From: Martyn White <Martyn.White@arun.gov.uk> **On Behalf Of** Conservation Officer
Sent: 13 February 2026 14:16
To: Planning.Responses <Planning.Responses@arun.gov.uk>
Cc: Rhiannon Lloyd <Rhiannon.Lloyd@arun.gov.uk>
Subject: A/10/26/PL

A/10/26/PL

Corner House, The Square, Angmering, BN16 4EA

Replacement of 9 No existing sash timber windows and 1 No door front and 1 No fire door with uPVC. This application affects the Angmering Conservation Area

Technical detail: 3 - Flat Windows - Supply & Fit - Remove & replace

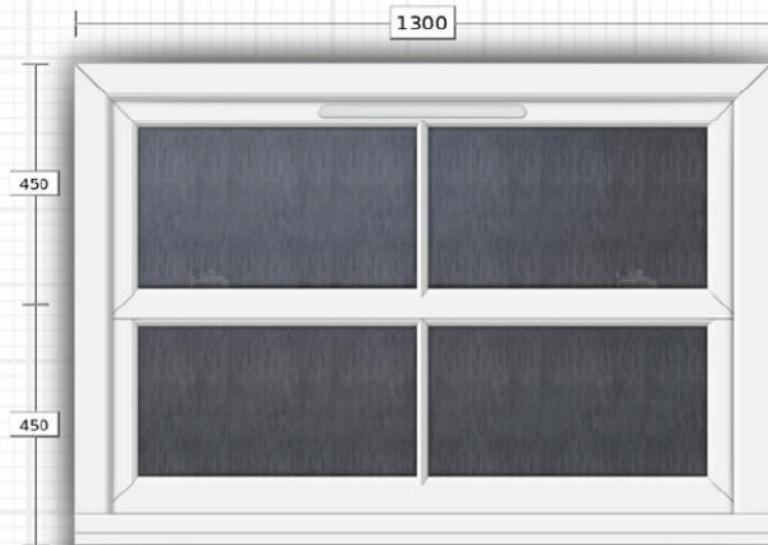
From a heritage perspective uPVC replacement windows are generally not suitable for older or historic buildings such as this one (non-designated heritage asset), particularly in prominent locations within conservation areas. Their use in this context is problematic and cannot be supported for several reasons:

Impact on appearance and character - uPVC windows fail to replicate the authentic, historical character of traditional timber windows, with the result being that they can significantly alter the character of an older building. Because the material is less rigid than timber, the frames must be manufactured with thicker sections, resulting in bulkier profiles. Their detailing also differs from traditional construction – even where they attempt to do so. For example, historic glazing bars in traditionally constructed windows are solid timber or metal and physically separate each pane of glass, whereas in many uPVC units the effect is merely simulated by thin plastic strips within a double-glazed unit, giving a noticeably different appearance.
